To	Miljan Tepic	Date	15 November 2021
Copies	Kyle Dukes	Reference number	257913-01
From	James Edwards +02 9320 9166 151 Clarence Street, Sydney	File reference	MEM
Subject	SCH1-CCCC SSD-10831778 Response to DPIE Request for Additional Information - Randwick City Council Submission

Randwick City Council's Response to Submissions on the State Significant Development (No. 10831778) has requested that Sydney Children's Hospital Stage 1 and Children's Comprehensive Cancer Centre (SCH1/CCCC) provide an additional 0.5m of footpath width to accommodate a Shared Path (total 3m wide) on the southern side of High Street as shown in Figure 1.

Figure 1 – High Street shared space option

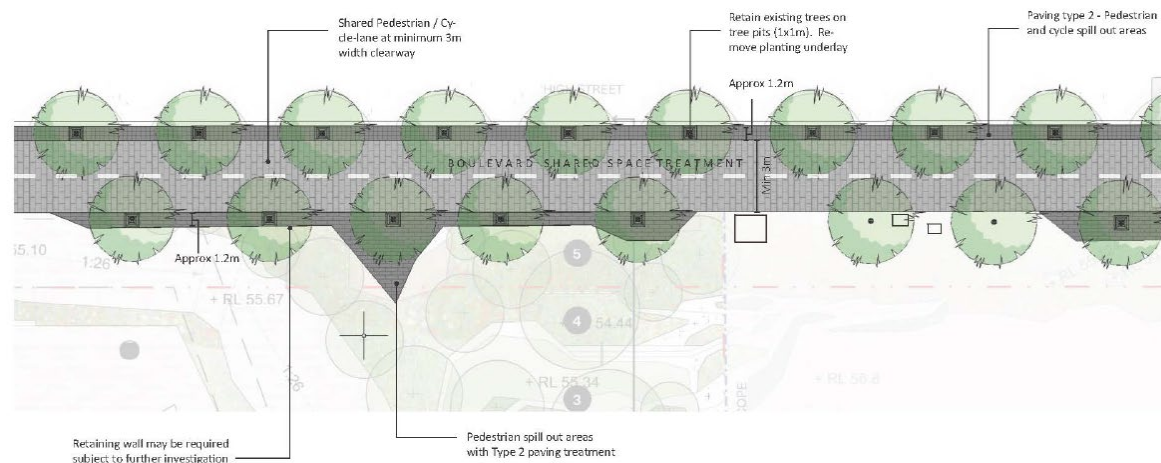
Council’s response included a suggestion that landscaped buffers around stormwater pits could be confined to pit locations, but these would still restrict the width of the Shared Path provided. Provision of a 3m wide Shared Path, but with concessions around stormwater pits, is akin to providing a path of narrower width or introducing hazards to the Shared Path and is regarded as undesirable for cycling infrastructure. Intrusions into roadways and un-trafficable hazards in road surfaces are not permitted, nor should they be tolerated in planning of active transport paths.

The south side of High Street is unsuitable for a Shared Path due to:

- Inconsistent path width due to parking indentations, street furniture and signal infrastructure means a shared path on High Street could not be continuous under current conditions,

- Inconsistency of cycling provisions along the length of High Street would likely increase conflict point risks if cyclists are entering and exiting the roadway in multiple locations. Confident cyclists would likely use the roadway while less confident cyclists would be put at greatest risk,

- Concessions around stormwater pits would result in a reduced effective path width for the length of the subject site. Introducing hazards to the Shared Path and is regarded as poor planning and design of cycling infrastructure.

- Steep grade falling from east to west, increasing likely bicycle travel speeds in that direction, beyond the acceptable limits for shared paths. Confident, experienced cyclists would be likely to use the roadway to facilitate higher speeds,

- High Street is signed a High Pedestrian Activity zone, including higher than normal proportions of vulnerable users including people with limited mobility, pregnant women, and children. Placing cyclists into this environment introduces an unnecessary risk to vulnerable pedestrians.
